Applicant: King Construction Corp.

Address: 1 Stepping Stone Lane (Lot #1)

perm. # 2013-00204

CHECK-LIST AGAINST ZONING ORDINANCE

A-4
OF SHEETS

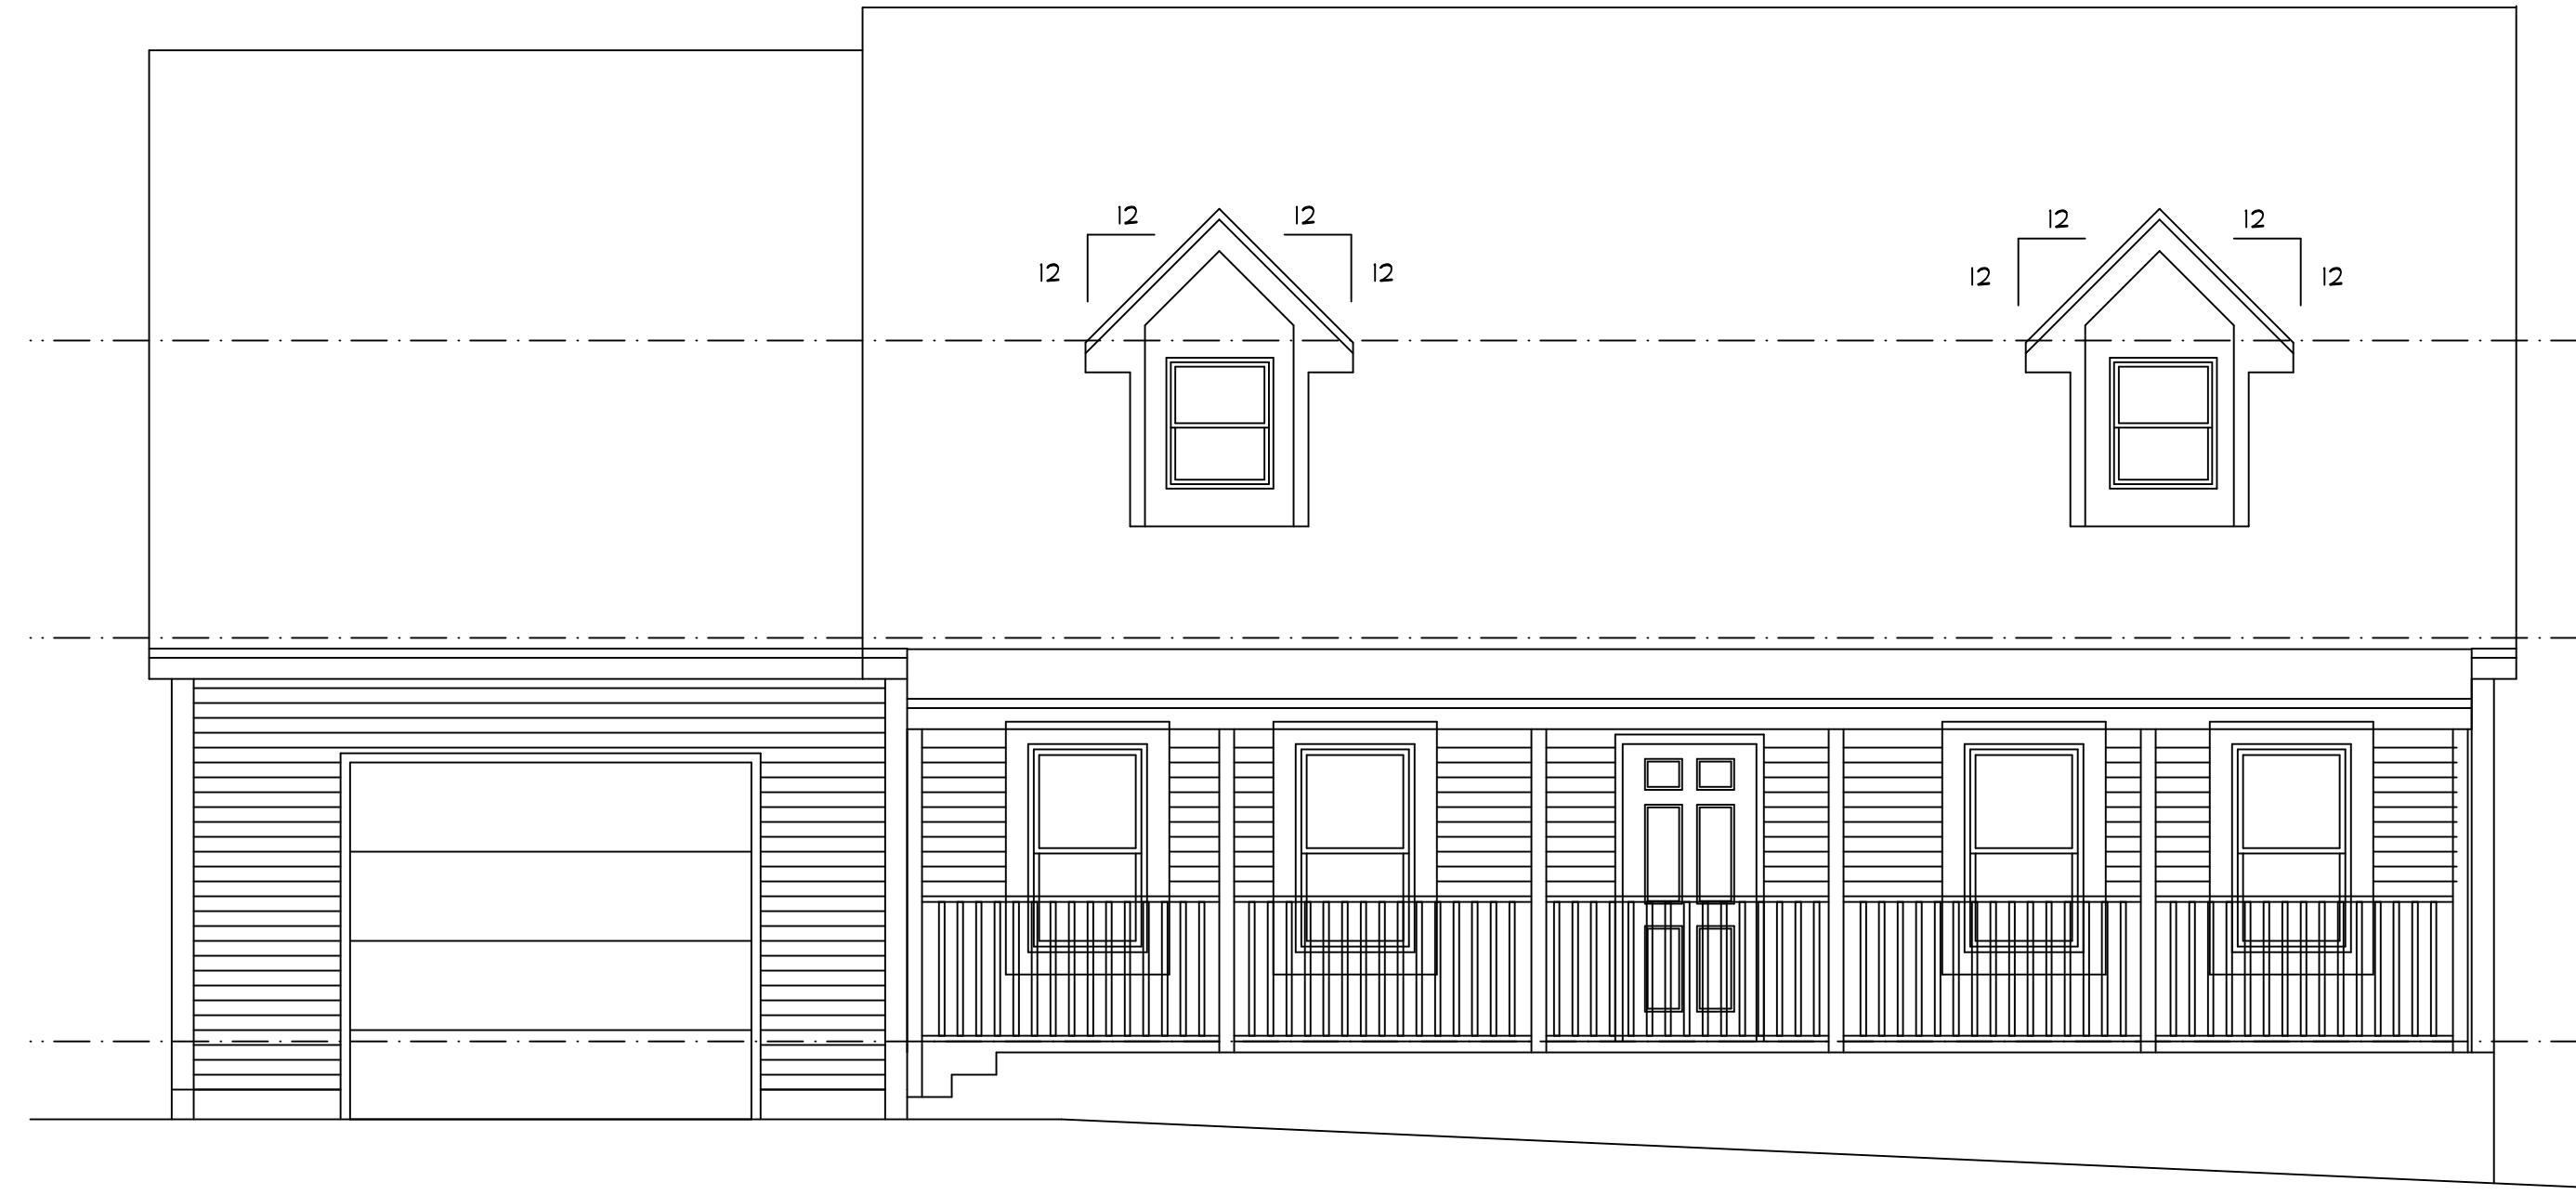
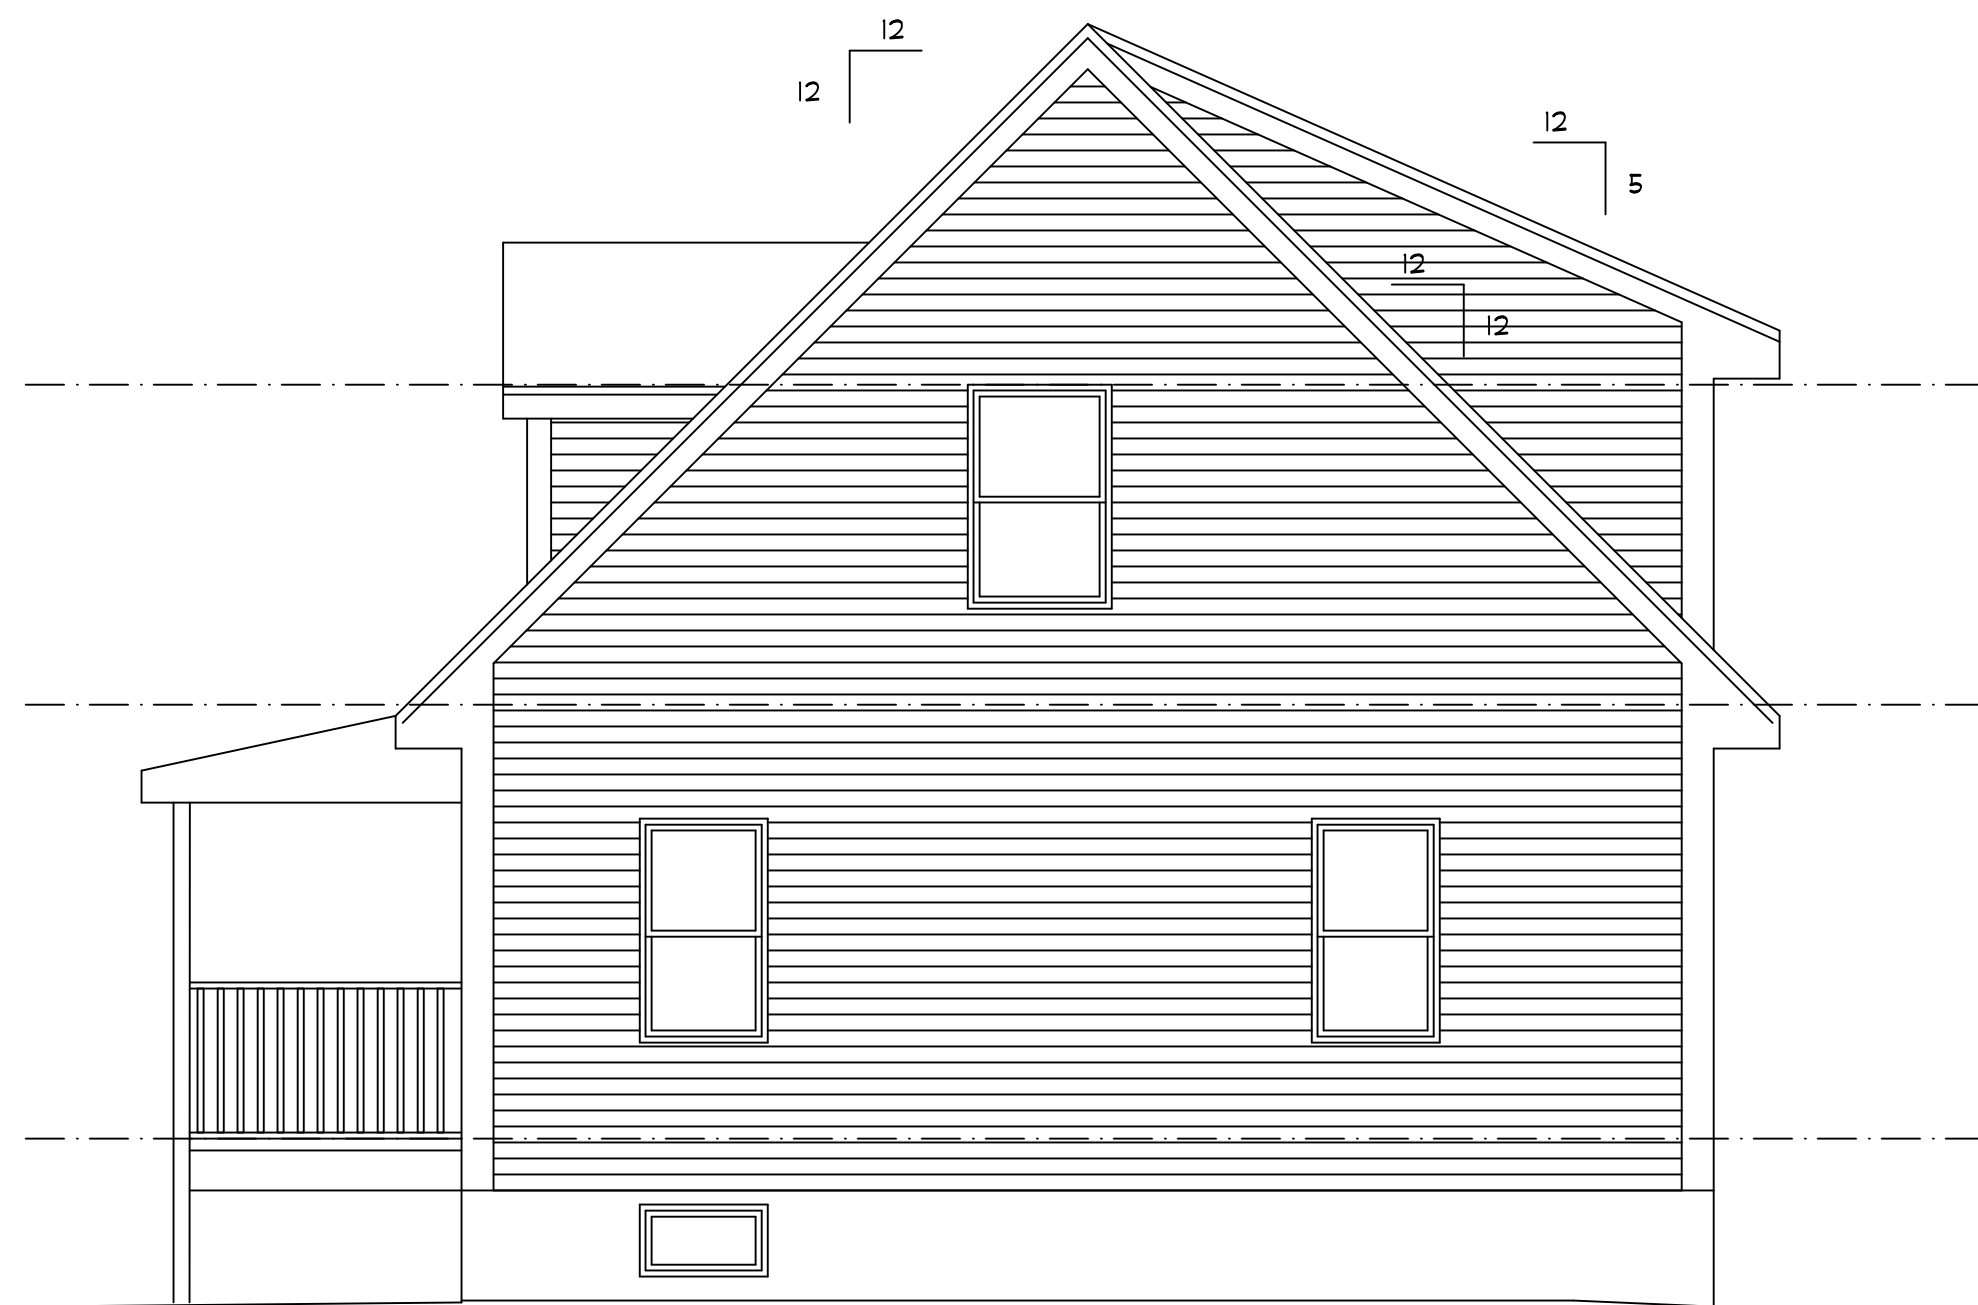
Height - 35' max - 25' to ridge (OK)
